**KIRKLEES COUNCIL
TOWN AND COUNTRY PLANNING ACT 1990
HIGHWAYS DEVELOPMENT MANAGEMENT**

PLANNING REF 2018/62/90735/W0/WS
CATEGORY Small Major

PROPOSAL DEMOLITION OF FORMER FIRE STATION AND ERECTION OF 24NO TWO BEDROOM FLATS.2NO SINGLE BEDROOM FLATS AND 1 NO DWELLING(WITHIN A CONSERVATION AREA)

LOCATION MARSDEN FIRE STATION
MANCHESTER ROAD
MARSDEN
HD7 6HA

### PLANNING LAYOUT

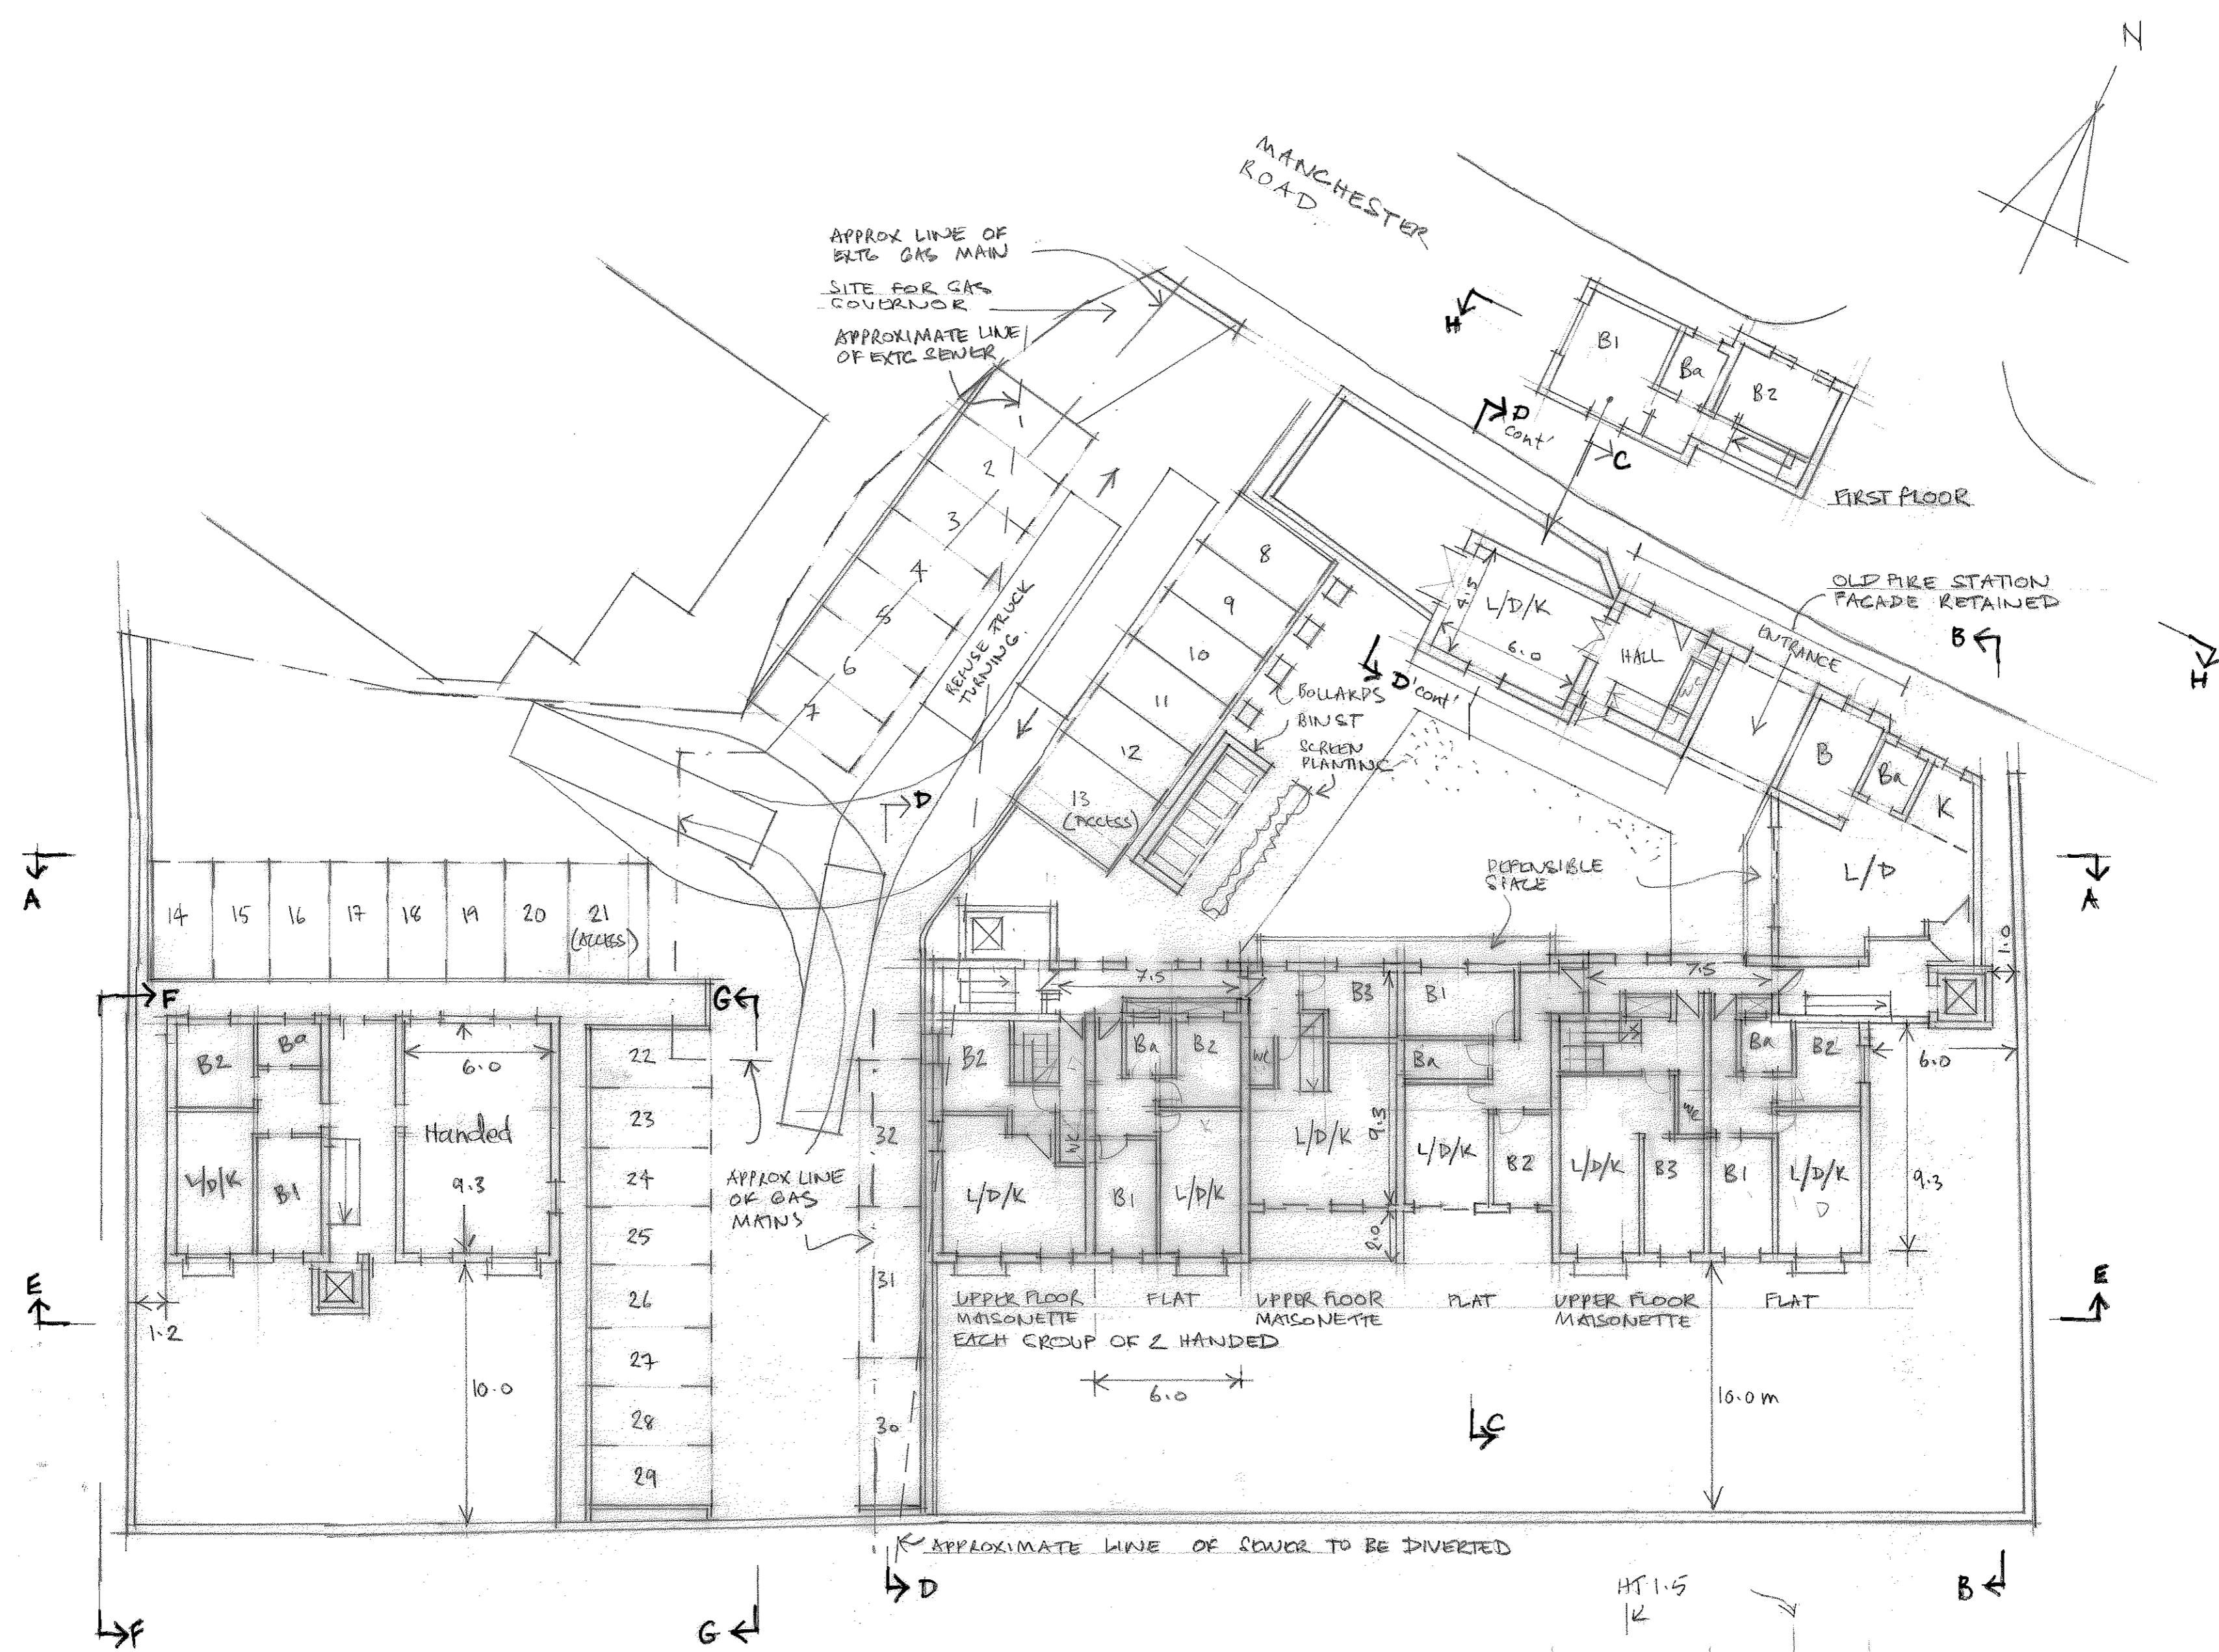
Internal turning has been demonstrated for an 11.85m refuse collection vehicle, although the bin store is in an acceptable location the size should be of such to accommodate 5no 1100mm grey bin and 5no 1100mm green bins (10 in total) to facilitate a fortnightly bin collection.

HDM would suggest consideration be given into resolving the refuse collection issues before the proposal is considered acceptable from a highways prospective.
